Department of Primary Industries

OUT16/17750

**ResourceGo Resource Recovery Facility Wetherill Park (SSD 7256)
Comment on the Environmental Impact Statement**

Modified Cut and Fill Diagram

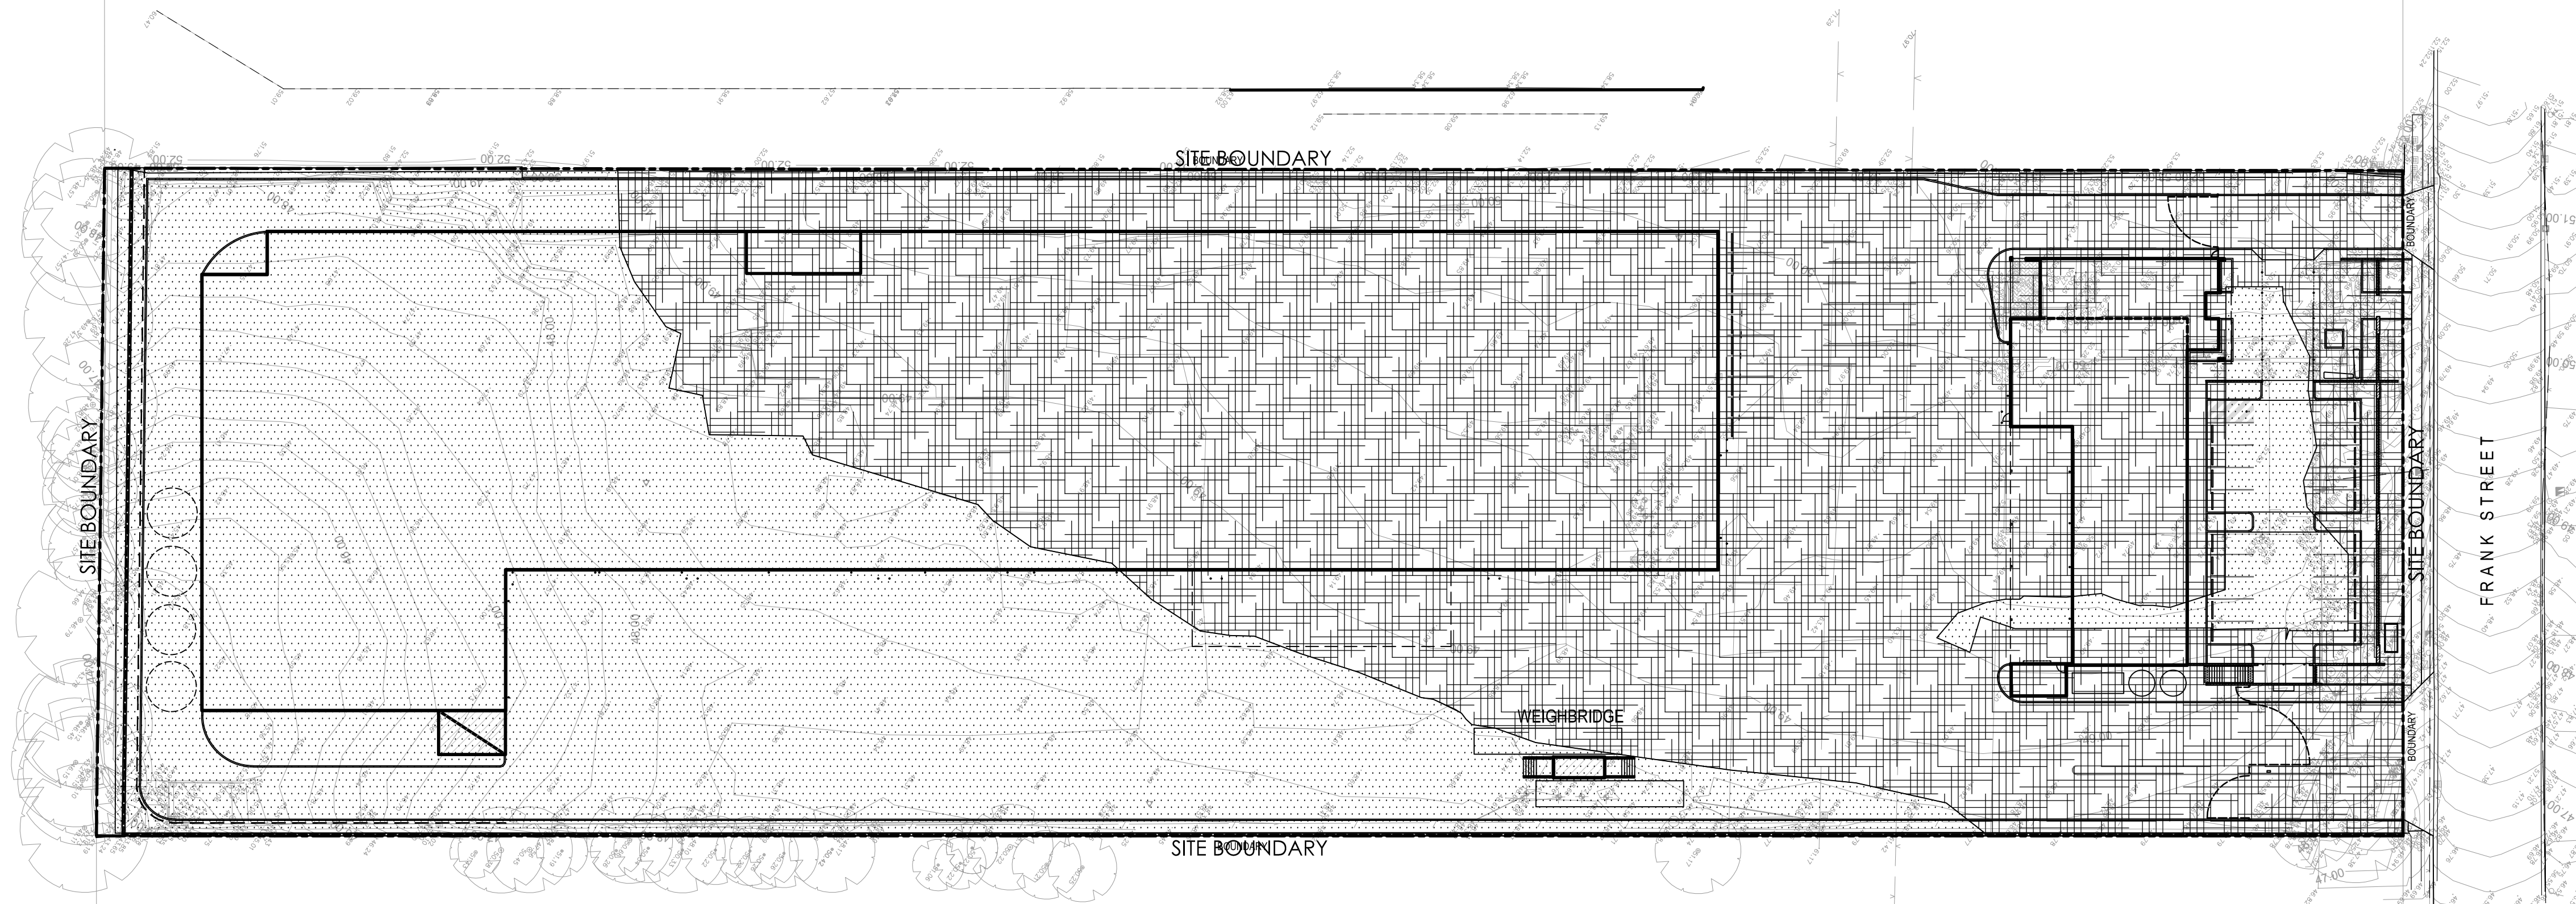
The SEARs require the EIS to assess potential impacts on groundwater. The EIS notes the site would be fully sealed and would therefore have no impact on any groundwater underlying the site (see Section 9.6, page 9.8). It also indicates significant earthworks would be required to achieve a level site and the site works would include cut and fill (see Section 13.4.2, page 13.5). It is unclear if the proposed cut is likely to intercept groundwater.

Should excavation intercept groundwater and there is a requirement to extract groundwater or to dewater, including any ongoing take of groundwater, then DPI Water needs to be advised and a licence may be required.
